Application Ref: H14-0640-26

Proposal: **Erection of 9 detached bungalows - Approved under H14-0042-24. Modification of Condition 2 to allow amendments to previously approved plans**

Location: **Land off Crossgate Lane, Pinchbeck, Spalding, PE11 3XW**

Deferral: LCC is not currently in a position to support the application and requests further assessment, supporting evidence, revisions and/or dialogue, as set out in the response.

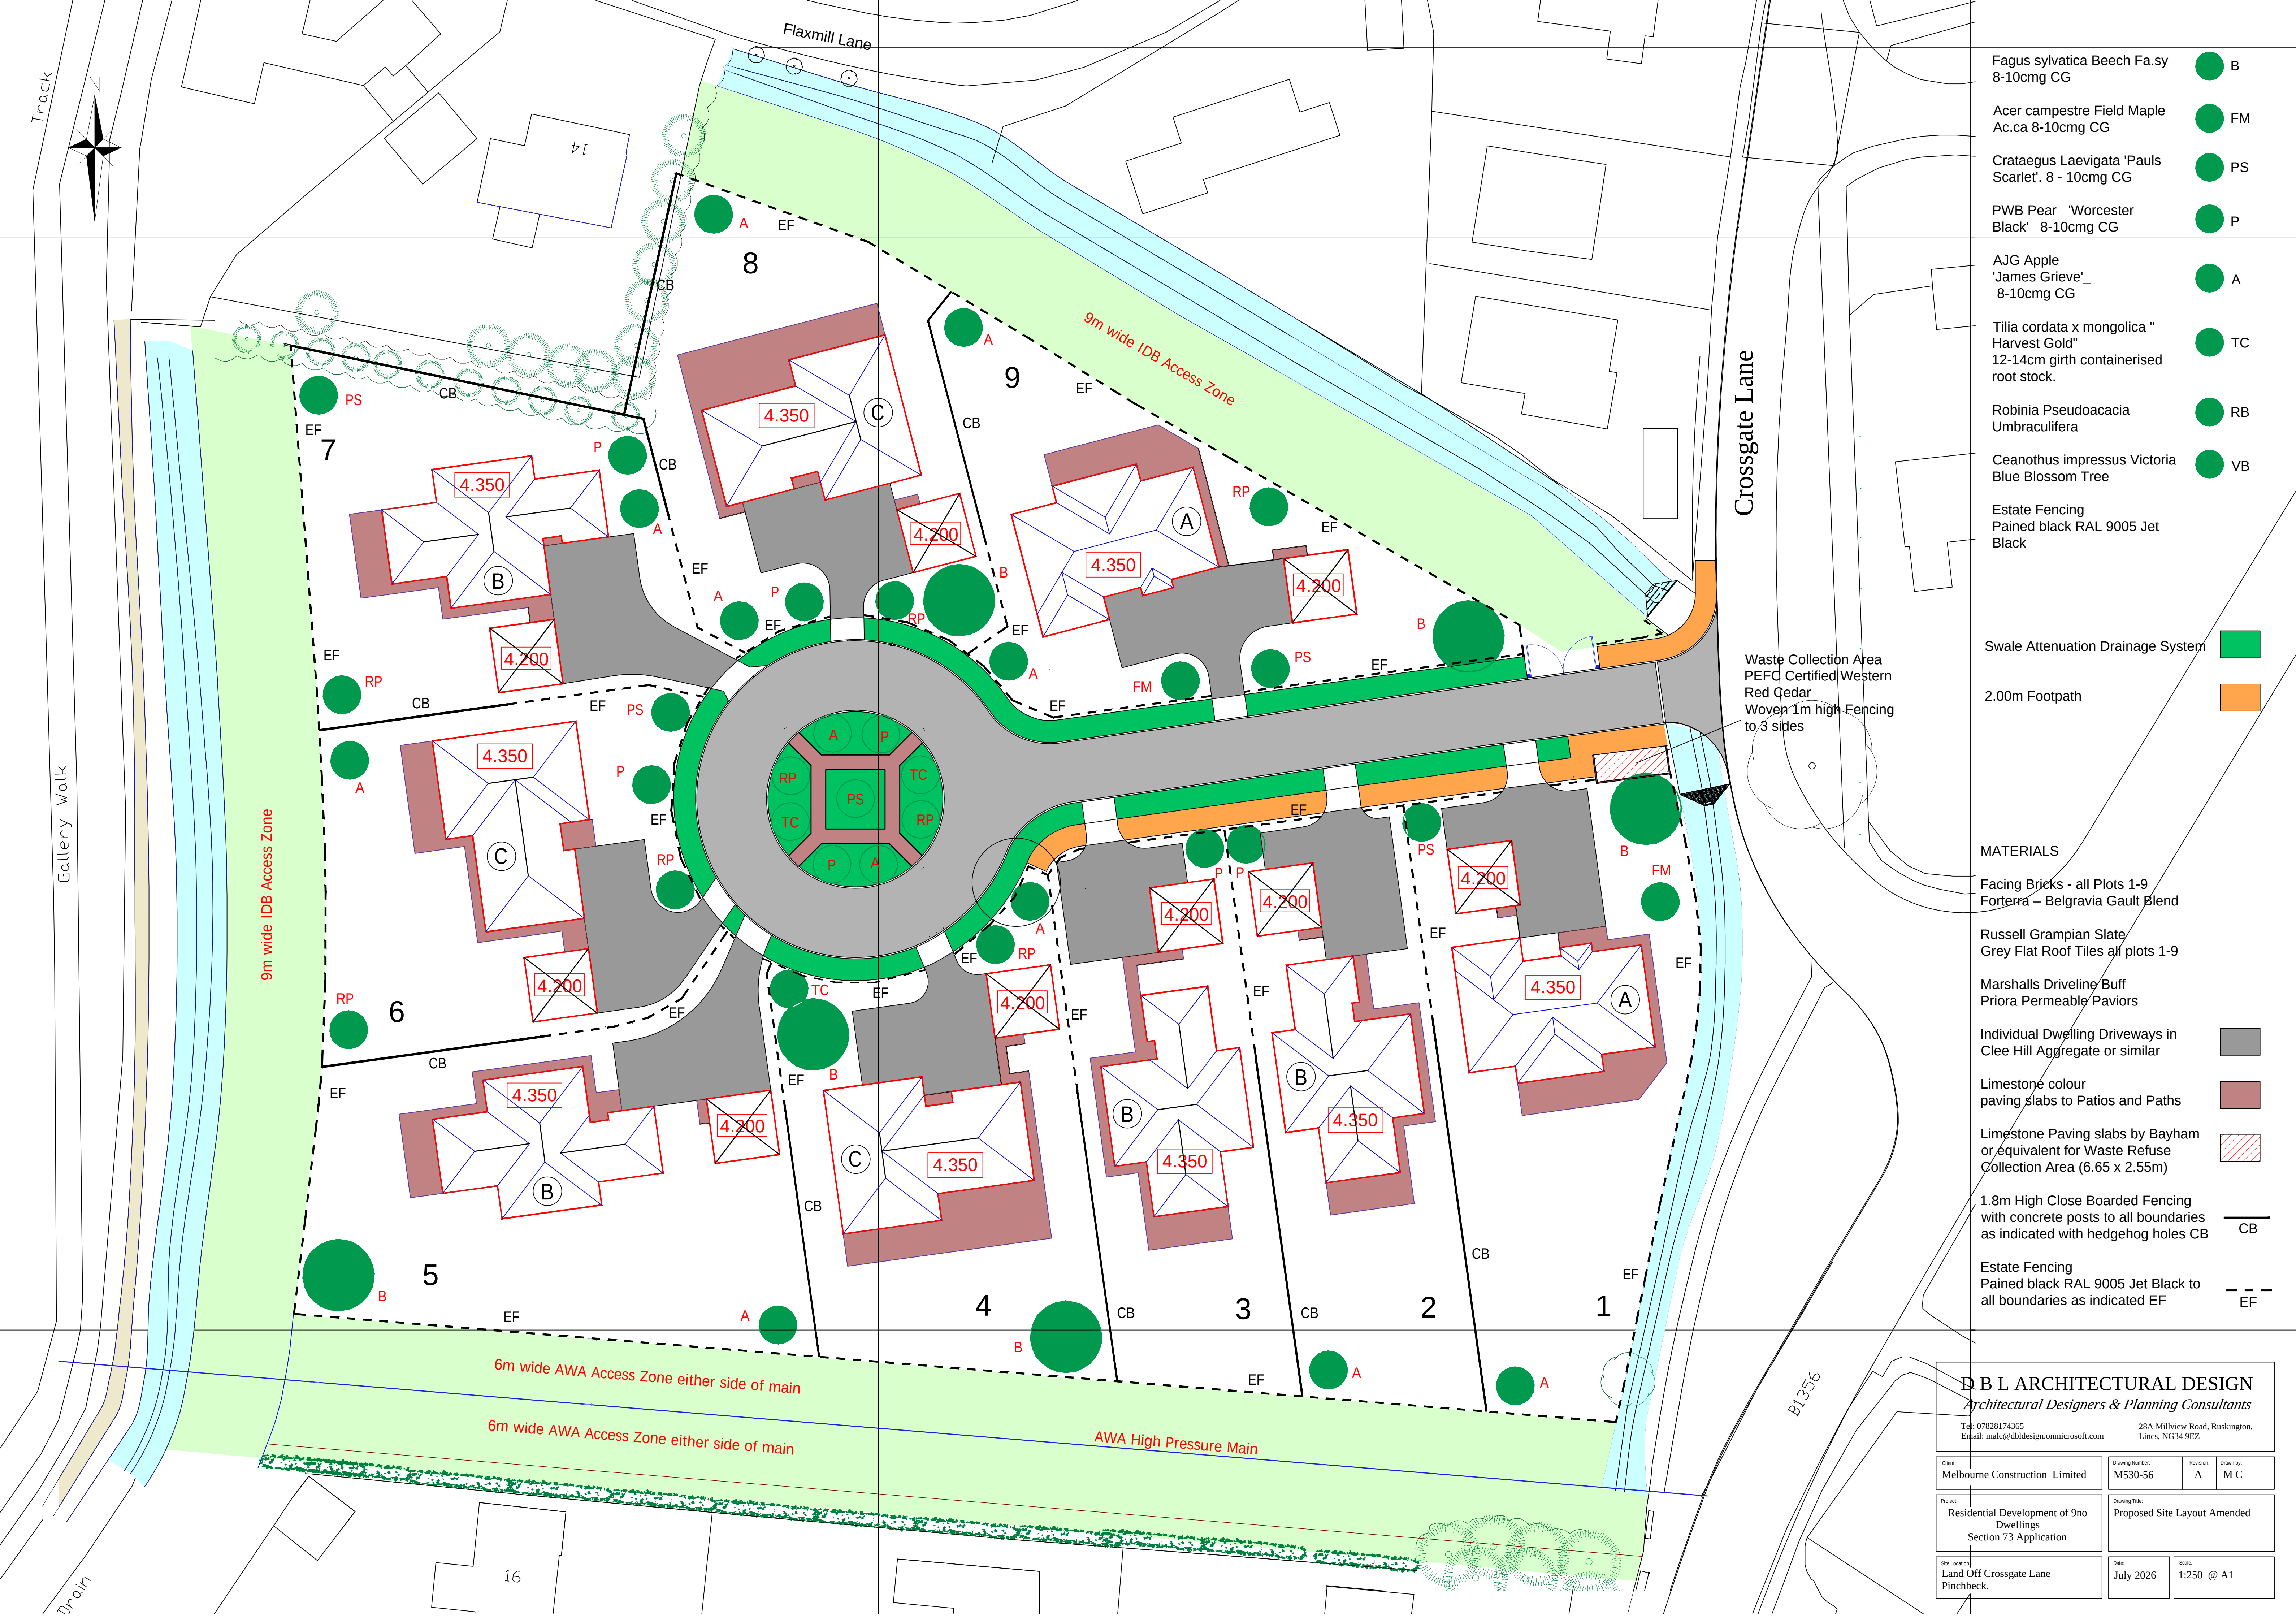
The site would benefit from the removal of the footway along the southern side of the private access road, insofar as it serves only three plots and there is no pedestrian connection across the swale to the west of Plot 3. Given that the access serves only nine dwellings, the private road could instead be designed as a shared surface, which would provide additional opportunity for landscaping and integration of the SuDS features.

There remains a requirement for a 2m-wide footway at the site access, together with an informal crossing point across Crossgate Lane. This detail has been omitted from the updated layout and should be provided, along with details of the culvert arrangement and confirmation that the access will be constructed to Lincolnshire County Council specification within the limits of the public highway.

The proposed footway adjacent to the access should also demonstrate how pedestrians, wheelchair users and other wheelers will transition safely and conveniently between the footway and the shared-surface environment.
